# **SCOPING OPINION:**

## **Proposed Salinae Hydrogen Storage Project**

**Case Reference: EN0310002**

**21 April 2026**

# FIGURE 2-1

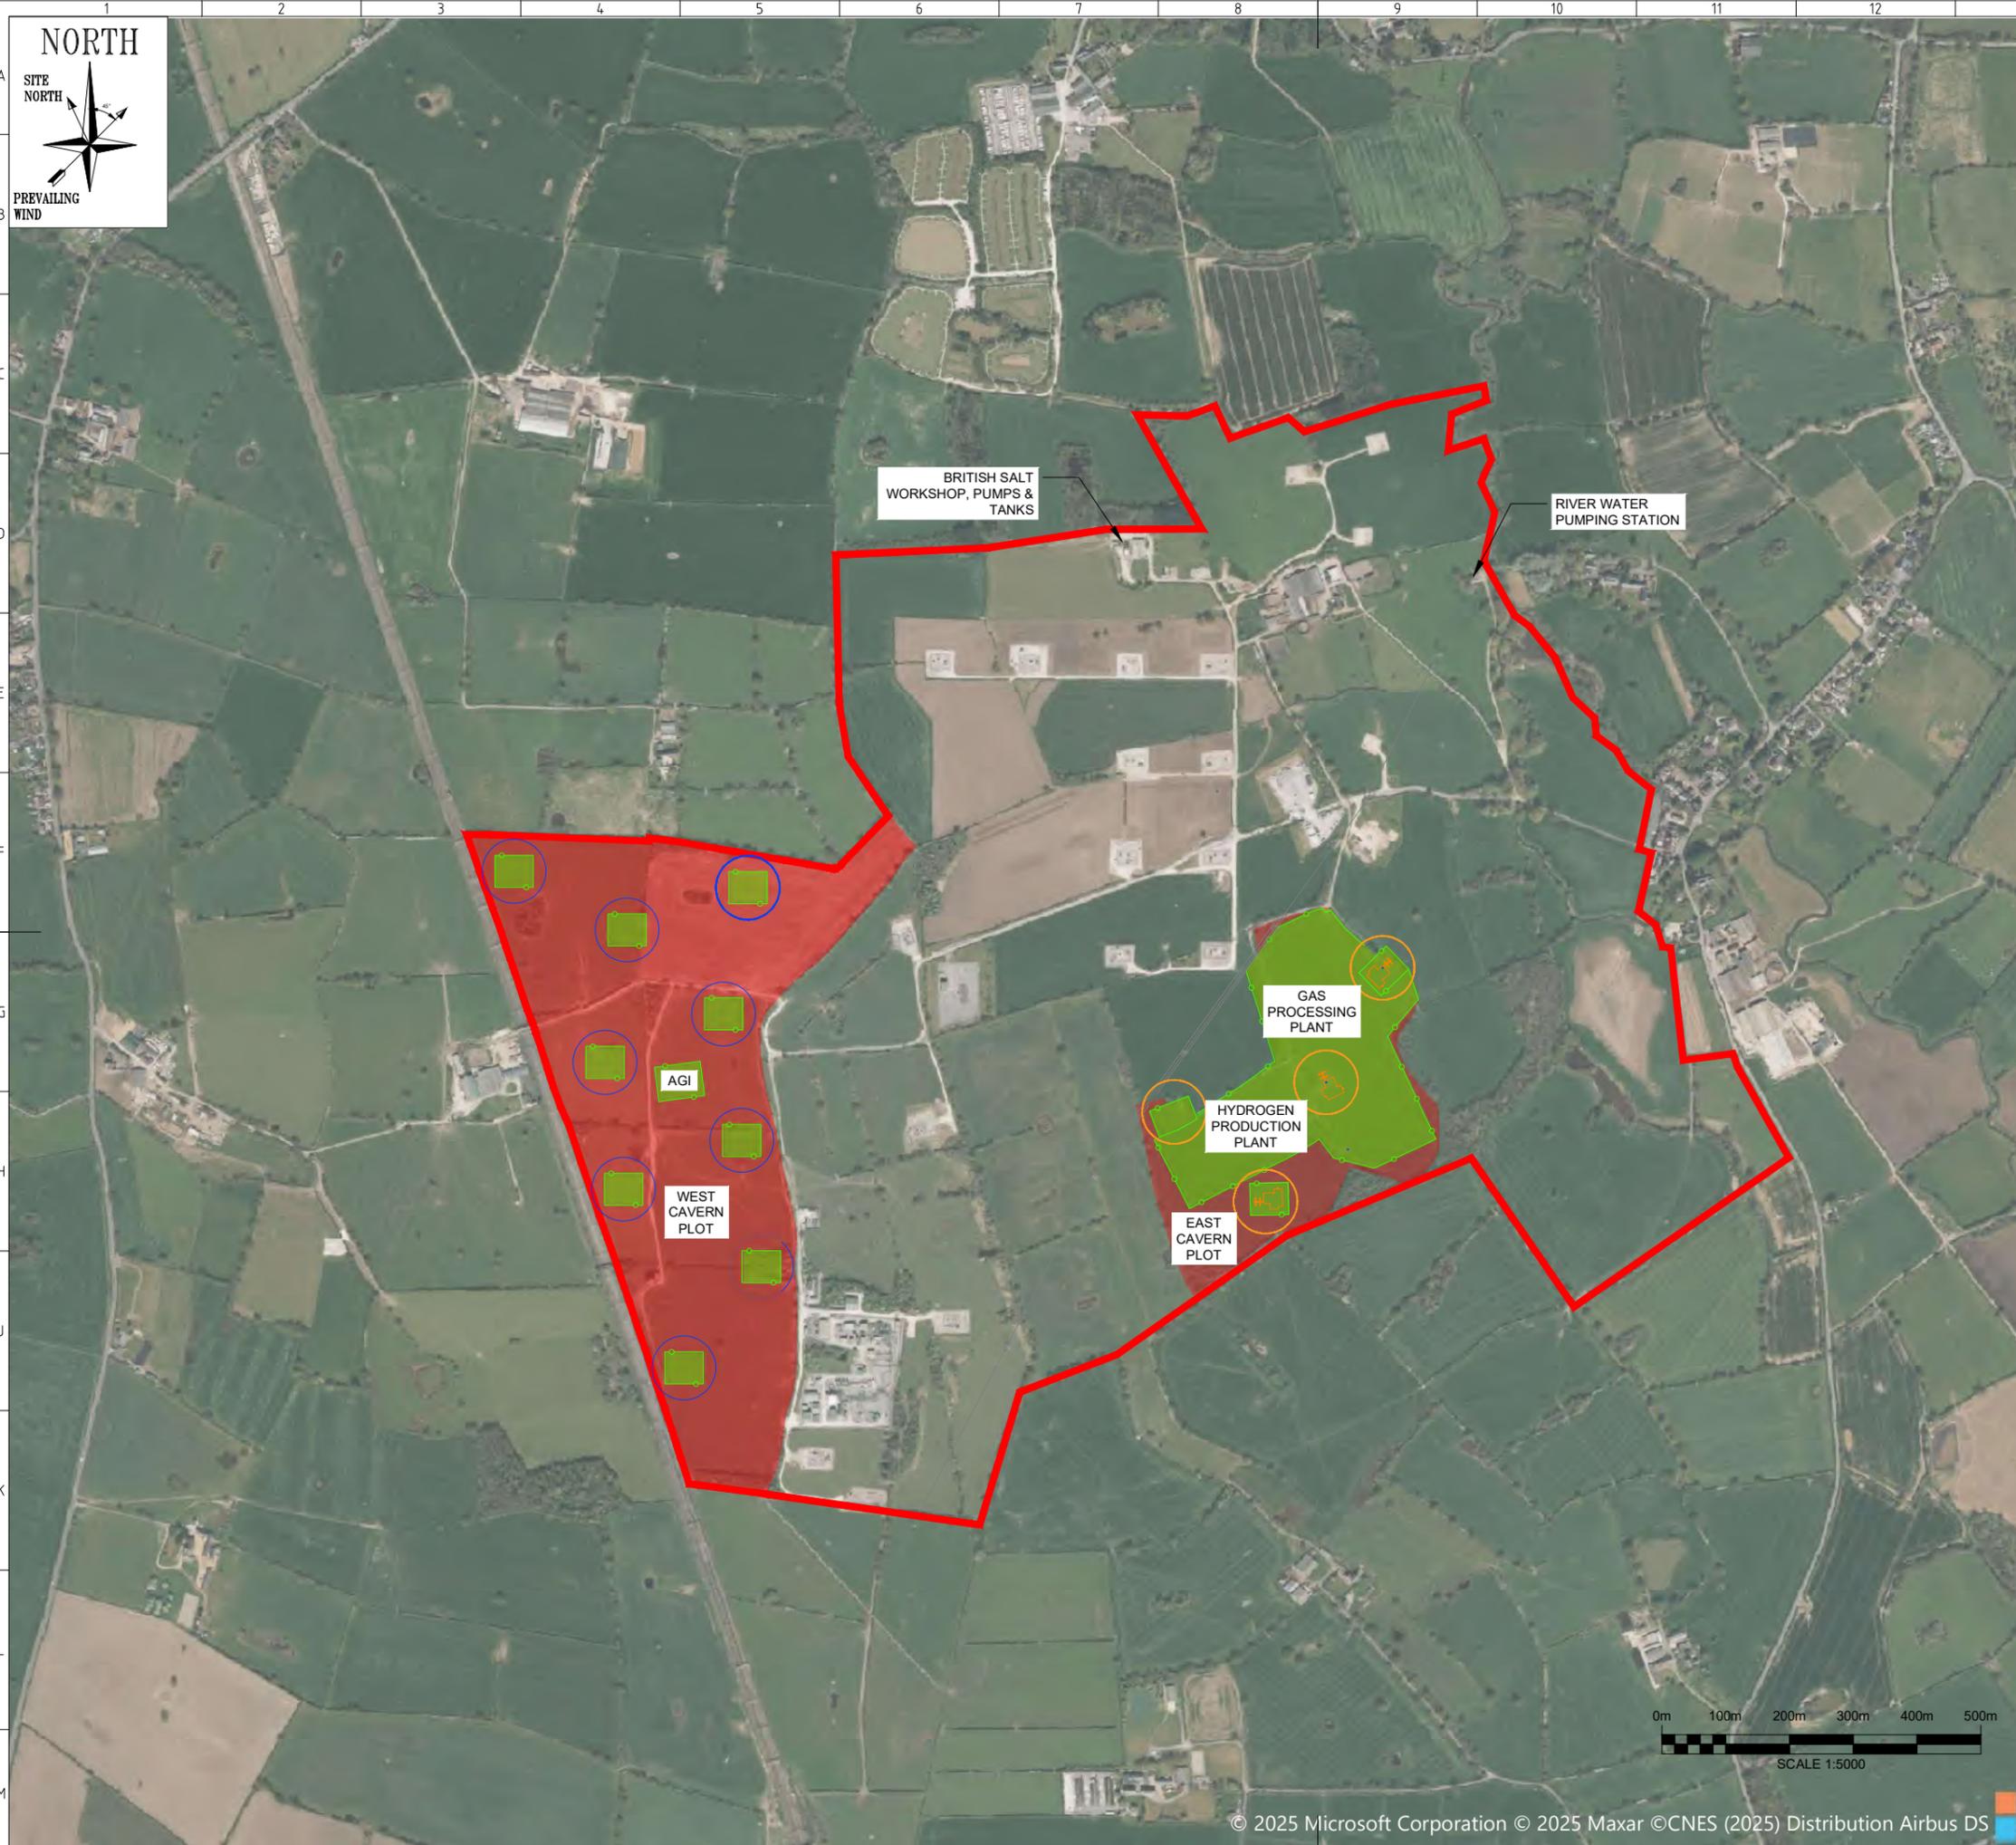
ID	Ref	Description	Inspectorate's comments
211	Table 2-1	Cavern parameters	The Scoping Report details the anticipated total storage capacity of the caverns. The ES should detail the anticipated depths and lateral extents of the caverns to be constructed.
212	Appendix A, figure 2-1: Indicative layout of the proposed development	Layout	<p>Appendix A, figure 2-1 is titled "Indicative layout of the proposed development". It identifies the site boundary, which is of greater extent than the proposed cavern plot boundaries and the process areas. Not all project elements described in the Scoping Report have been depicted on the figure, for example water, brine or hydrogen pipelines; electricity connections; pigging facilities; or temporary work areas. In the absence of indicative locations, it is difficult to visualise the proposed development in its entirety.</p> <p>Figures within the ES should clearly identify all project elements or land uses that would take place across the draft Order limits to inform understanding of the proposed development. A clear description of all construction and operational activities should be detailed within the project description chapter.</p>

213	Section 2.2	Existing land uses and planning permissions	Section 2.2 of the Scoping Report details the existing land uses within the proposed Order Limits. Appendix A, figure 2-1 provides indicative locations of these land uses, however does not delineate their full extent. It is unclear from figure 2-1 where the partially developed infrastructure associated with 7/2007/CCC/13 is located. Figures within the ES should clearly identify the extent of existing land uses and planning permissions. The ES should confirm whether any demolition of infrastructure associated with 7/2007/CCC/13 is required as part of the proposed development.
214	Section 2.5	Apparatus required at the caverns	The scale of apparatus required during the drilling and leaching phases is unclear. It is important that the ES clearly identifies the type and scale of equipment required to enable a robust assessment of effects.

# FIGURE 5-5

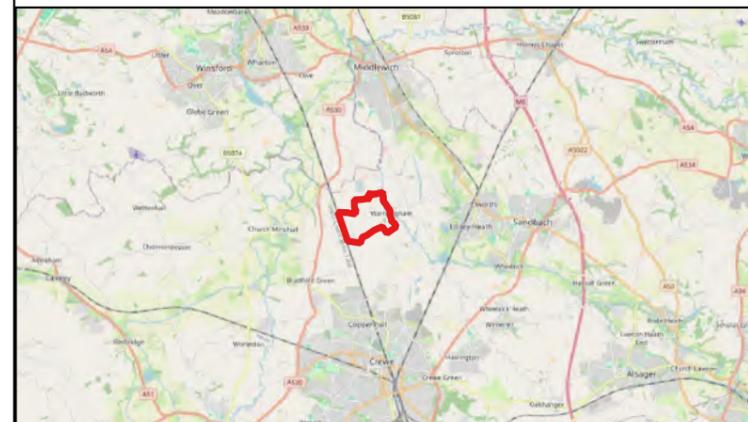
346	Appendix A, figure 5.5	Figures	Appendix A, figure 5.5 identifies the location of the River Wheelock Water Framework Directive (WFD) surface watercourse and main river. Further surface water features are described in section 5.5 of the Scoping Report. Their locations should be depicted on figures within the ES to facilitate understanding of the baseline environment.

ID	Ref	Description	Inspectorate's comments
34.7	Appendix A, figure 5-5	Flood defences	Appendix A, figure 5-5 identifies a flood defence in the eastern part of the site. At present, it is unclear what activities would take place in this part of the site. The ES should confirm whether the proposed development would impact on the structure and function of the flood defence structures and assess any implications on the flood risk at the site.
